FW: AL/67/25/PL Nyton Rest - SUB PLAN REQUEST

Please upload the attached as a new plan "Fire Tender Plan" and the email below as Planning Correspondence "Ref Requested Hose Lay Route Details"

From: Eamonn Prenter <[REDACTED]>
Sent: 13 February 2026 17:58
To: Simon Davis <Simon.Davis@arun.gov.uk>
Cc: alex baker <[REDACTED]> Bailey Russell <[REDACTED]>; Prithvi Gowda <[REDACTED]>
Subject: RE: AL/67/25/PL Nyton Rest - Suggested Planning Conditions

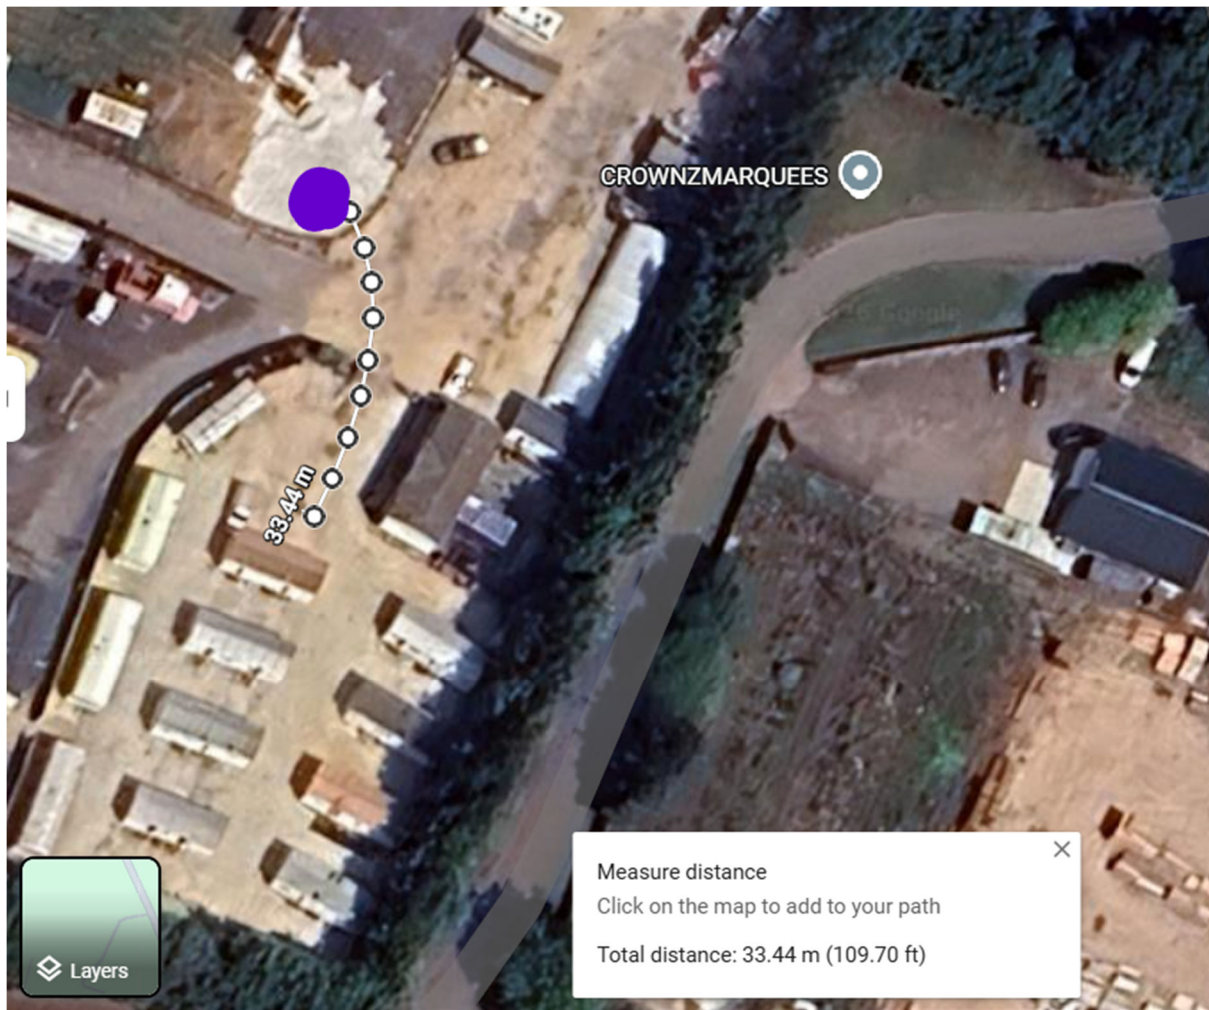
"The measurement from the water tank needs to be to the location the fire appliance attending the incident, which should be within 45-metres of all caravans to ensure we can reach them using the first response high pressure firefighting hoses connected to the fire appliance pressure pump.

If they measure 45-metres back from the furthest caravan, that would be the point the fire appliance will need to gain access to. The water tank will then need to be within 90-metres of the fire appliance location.

I have attached a screen shot of our mapping to give an idea of the point the fire appliance would be located, 45-metres from the furthest caravan. The water for firefighting tank can then be up to 90-metres away from this point, measured along the hose lay route."

The first satellite image below shows that the allocated location for the fire appliance within the application site can provide water to all caravans on site including those furthest away within a distance of 45m. The furthest caravan shown on the image below is 42m approximately. The preferred position for the fire appliance is shown with a white rectangle on the attached.

The second image below shows that with a water release valve for fighting purposes located on the eastern side of that tank (at approximately 3 O Clock) an almost straight line can be drawn from that point on the tank to the location where the fire appliance would be stationed as shown on the attached plan. That distance measured off Google Earth would be 33.44m from tank water release valve to fire appliance. That line can be drawn relatively straight because there is no field boundary at the location of the tank and there is also an open gate that can be used to bring the hose through. In other words there are no obstacles in the path in the proposed route of the hose.

Please note therefore in summary that all caravans are at least 5.25m apart with the majority 6m away. Those caravans that were located less than 5.25m apart from each other previously have now been relocated so that minimum distance is reached. Where that minimum 5.25m and not the more general 6m is reached Class 1 fire rated cladding will be provided and no non-fire rated materials or equipment will be kept between the caravans ie vehicles, tables and chairs etc. All caravans are within the 45m reach of the fire appliance and that the tank would be approximately 33m from where the fire appliance is expected to be stationed on the attached plan. There are no intervening impediments to interrupt waterflow with the site being flat and there being no impediments such as walls, hedges and fences to raise or lower the pipe such as to block or interrupt flow.
